KIRKLEES METROPOLITAN COUNCIL INVESTMENT & REGENERATION SERVICE

DELEGATED DECISION TO DETERMINE PLANNING APPLICATIONS

Reference No:	2026/62/91372/E
Site Address:	5, Cemetery Road, Westtown, Dewsbury, WF13 2SE
Description:	Change of use and alterations to convert existing basement to self-contained apartment
Recommending Officer:	Elenya Jackson

DECISION – CONDITIONAL FULL PERMISSION

Proposed South West Elevation

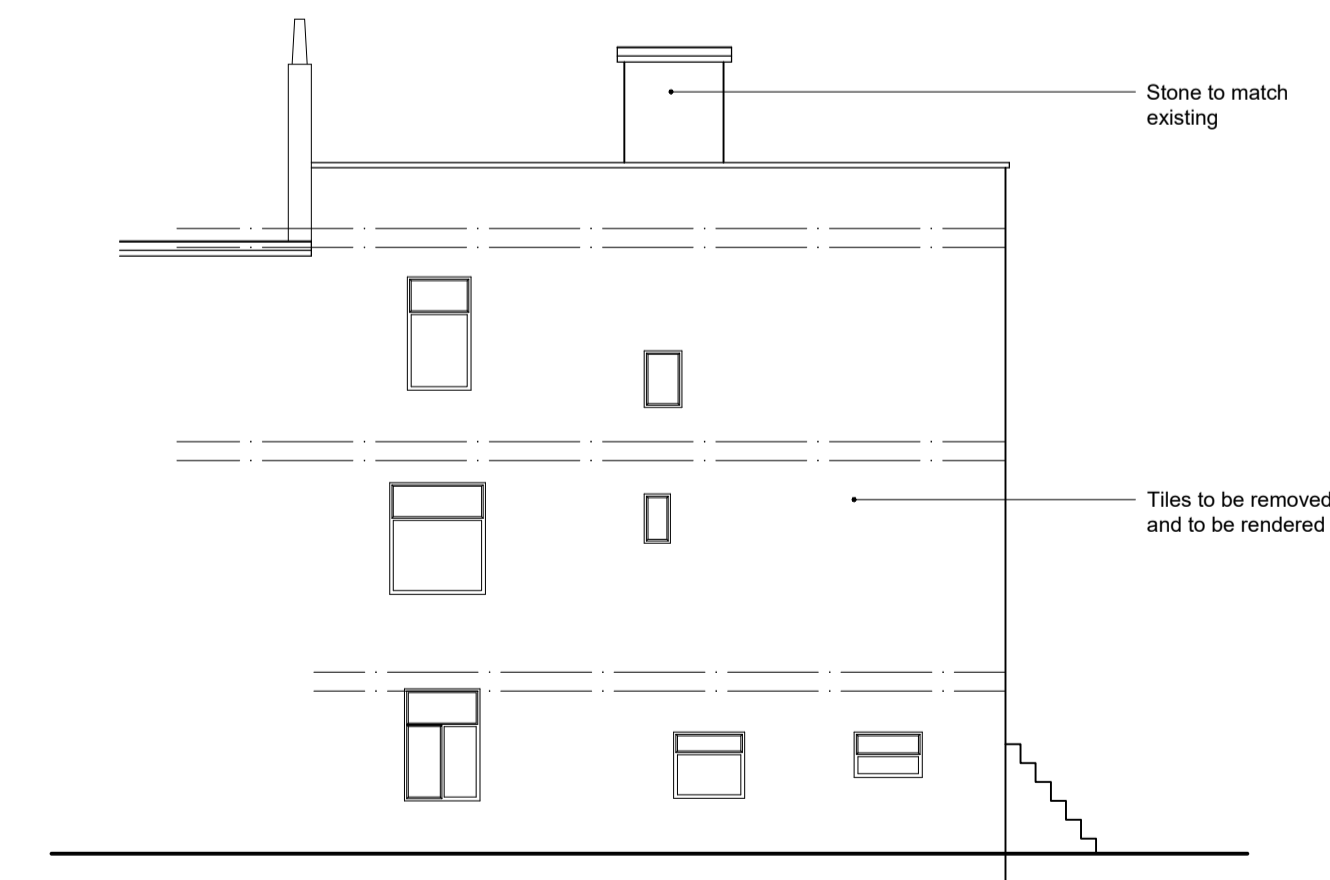
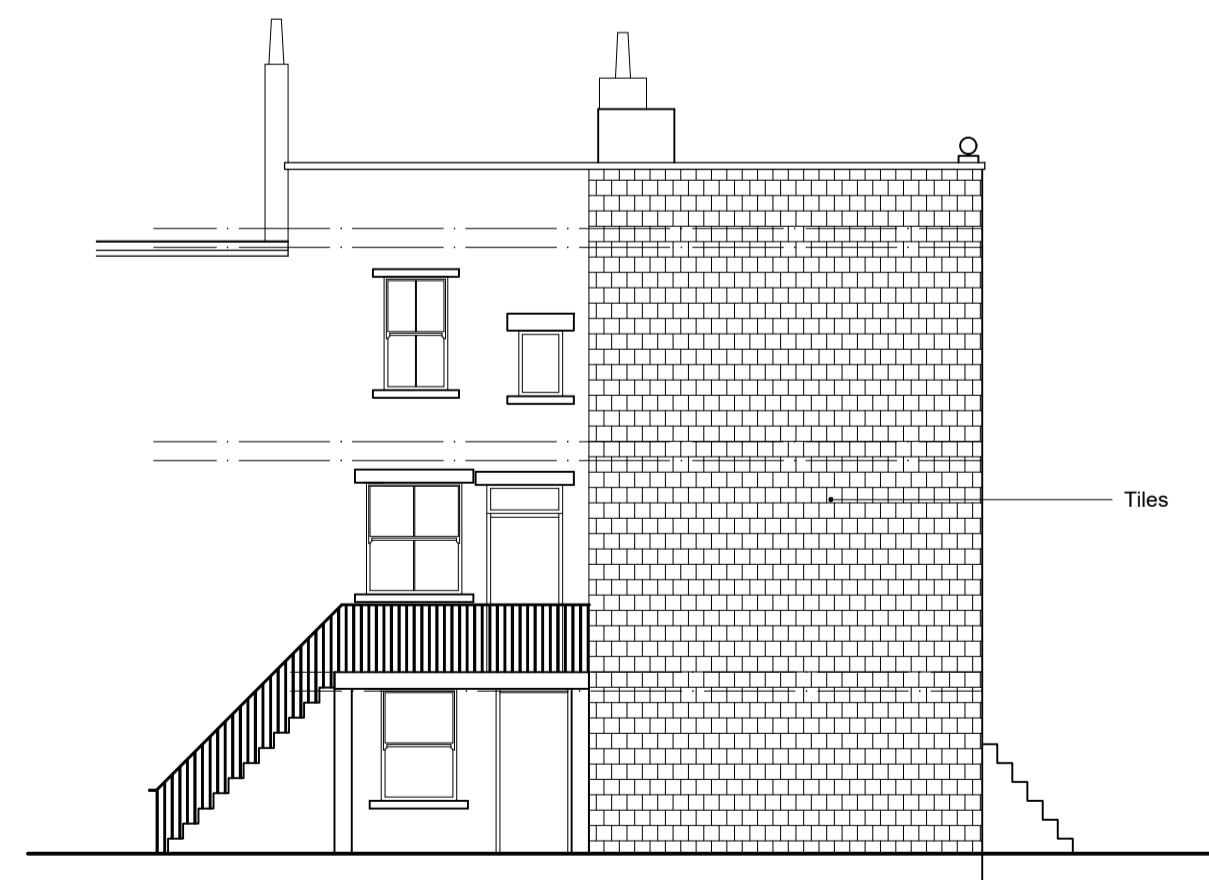
This would be facilitated by the addition of additional 5 additional windows in the south-west elevation of the building and the removal of existing tiles on the southern elevation and the application of render. (Officers acknowledge that the previous application on site stated the stone work underneath the removed tiles would be made good).

The proposed development would require minimal alterations to the exterior of the property. The removal of the existing tiles would be acceptable and it is acknowledged that the use of render is not characteristic of the building; however, officers consider that this would be limited in location and not overly prominent from the public realm. Officers would recommended the removal of permitted development rights to ensure the rest of the building is not rendered; however, as the site would become flats, they would not benefit from the same permitted development rights as a standard c3 dwelling and it is not considered necessary as a result. However, for clarity, officers shall condition that the render is limited to where the tiles have been removed.

The introduction of additional windows is not considered to have a significant visual impact given their design is largely in keeping with the character of the existing building.

3. Prior to installation, details of proposed render shall be submitted and approved in writing by the Local Planning Authority. Thereafter the development shall be completed in accordance with the approved details prior to being brought into use and retained as such for the lifetime of the development.

4. Notwithstanding the approved plans, the location of the render shall be limited to the south-western elevation of the building only and shall be retained as such for the lifetime of the development.
